AB/52/21/PL

Old Bank House 3 High Street Arundel BN18 9AD

Replacement of all windows with new timber double glazed sliding box sash windows and the proposed rendering of the South Elevation (front) with render painted white

No.1 No.3
PROPOSED SOUTH ELEVATION (1:100)

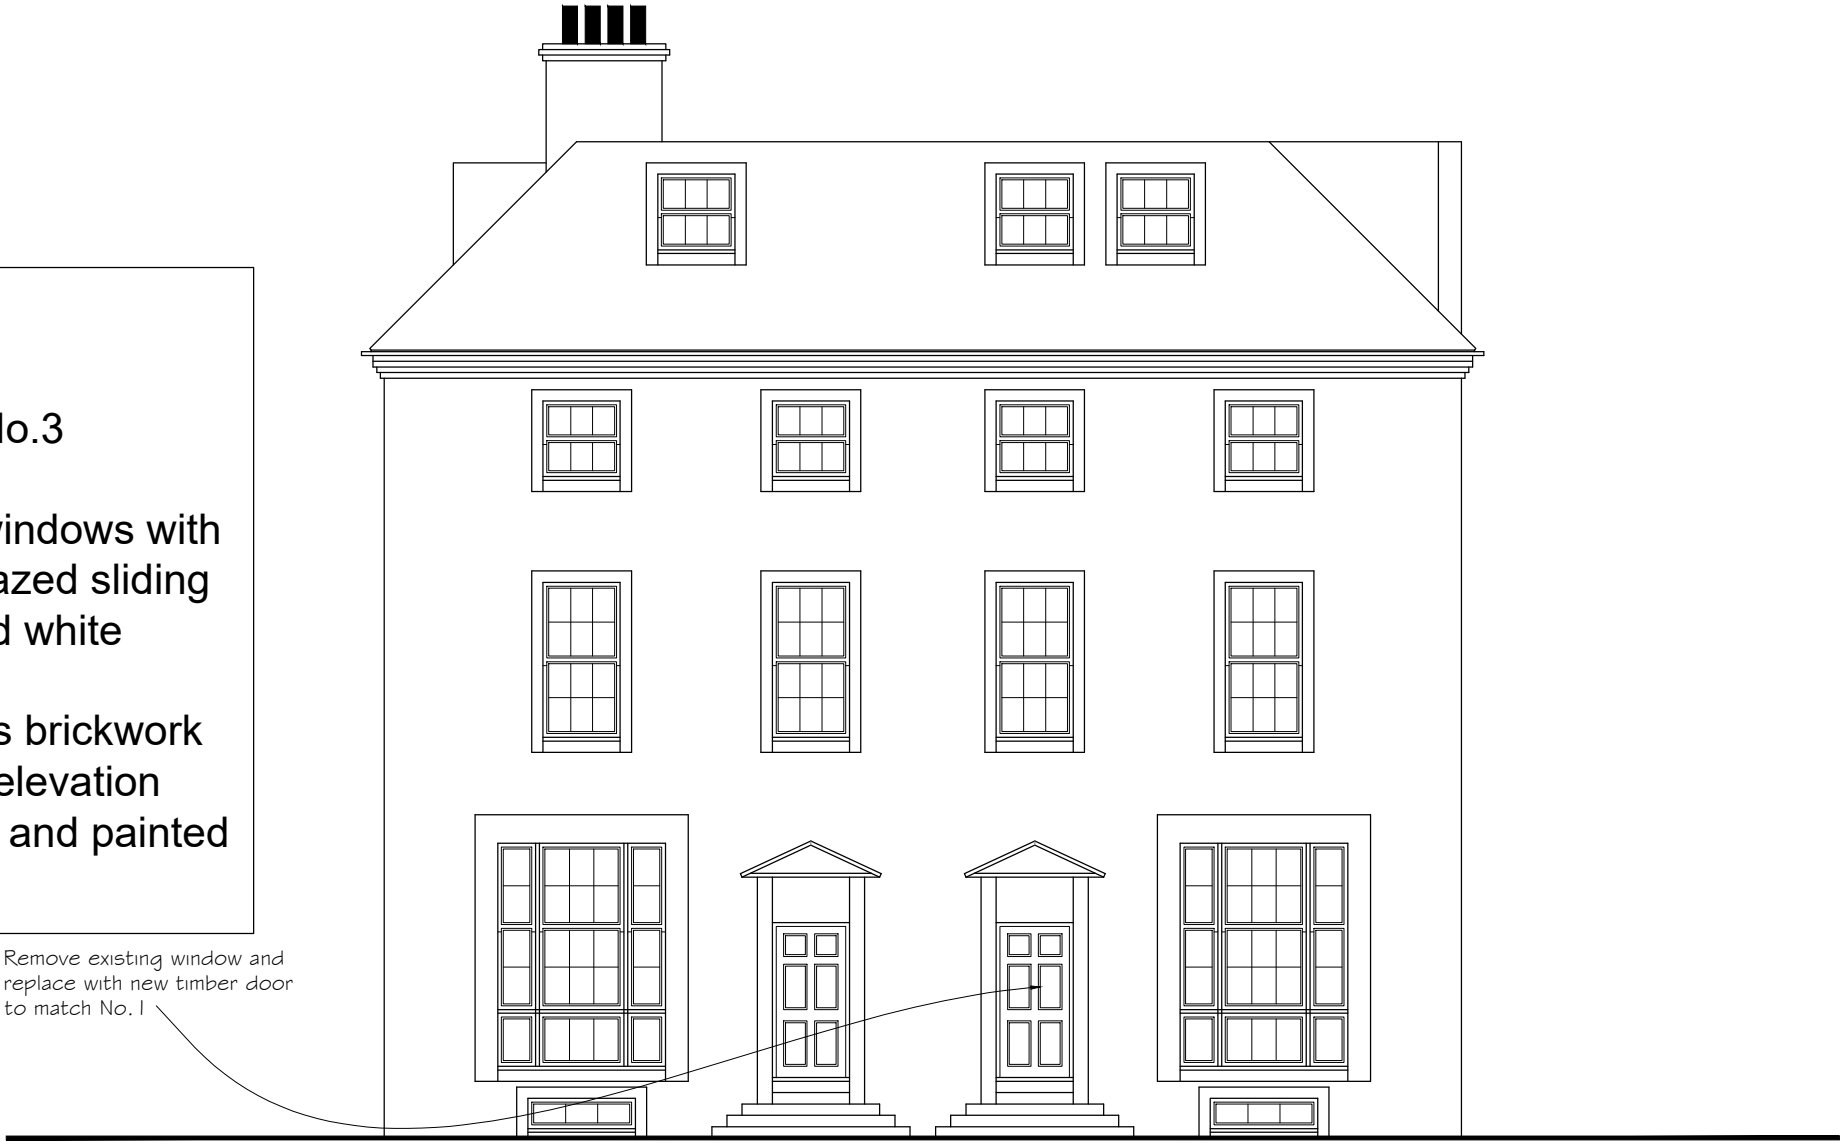
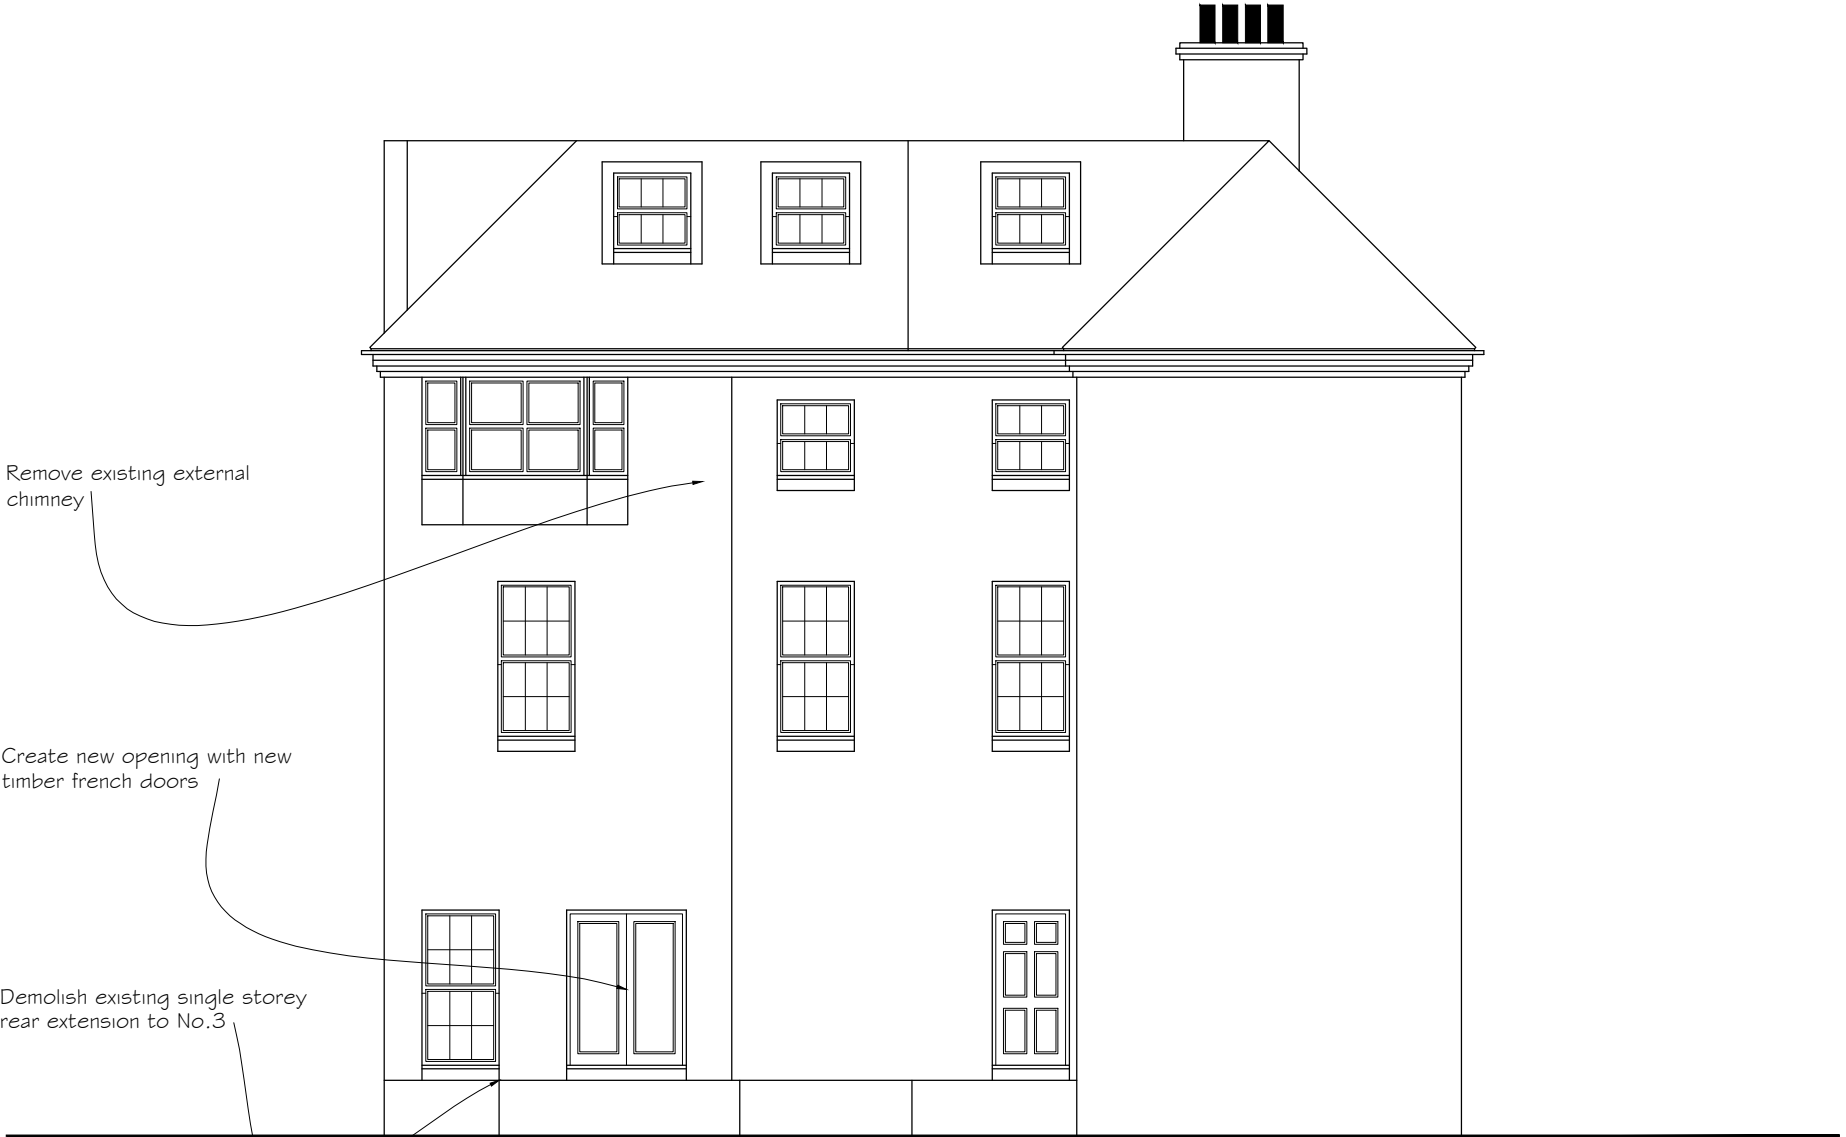
The wholesale replacement of the existing windows would represent a substantial loss of historic fabric, where the initial approach should be to repair the existing ones. It is not clear if any information has been provided which indicates the current condition of the windows or if they are beyond repair. This information should be provided.

Whilst a number of plans have been provided, they do not provide full elevational details which makes it difficult to understand what their appearance would be. This is especially true of the ground floor windows where there is an additional fixed sash. Would they be the same or different? Unfortunately, it is not clear.

It is also difficult to understand from looking at the information provided how any glazing bars, if any, will be treated. There are two approaches that could be used: to use glazing bars that are applied to one pane of glass or to use properly formed bars, but these would need to be thicker than the originals in order to take the extra weight of the double glazing (this would also likely be the case even with slimline double-glazed panes due to their size).

It would help to have historical information to confirm the presence of historical render on this elevation. It is also not clear how existing details such as the brick dentil course at eaves level will be treated as part of the process of applying render, or what materials will be used in this traditional property. This needs to be confirmed as the process could cause negatively impact the building and features and cause harm.
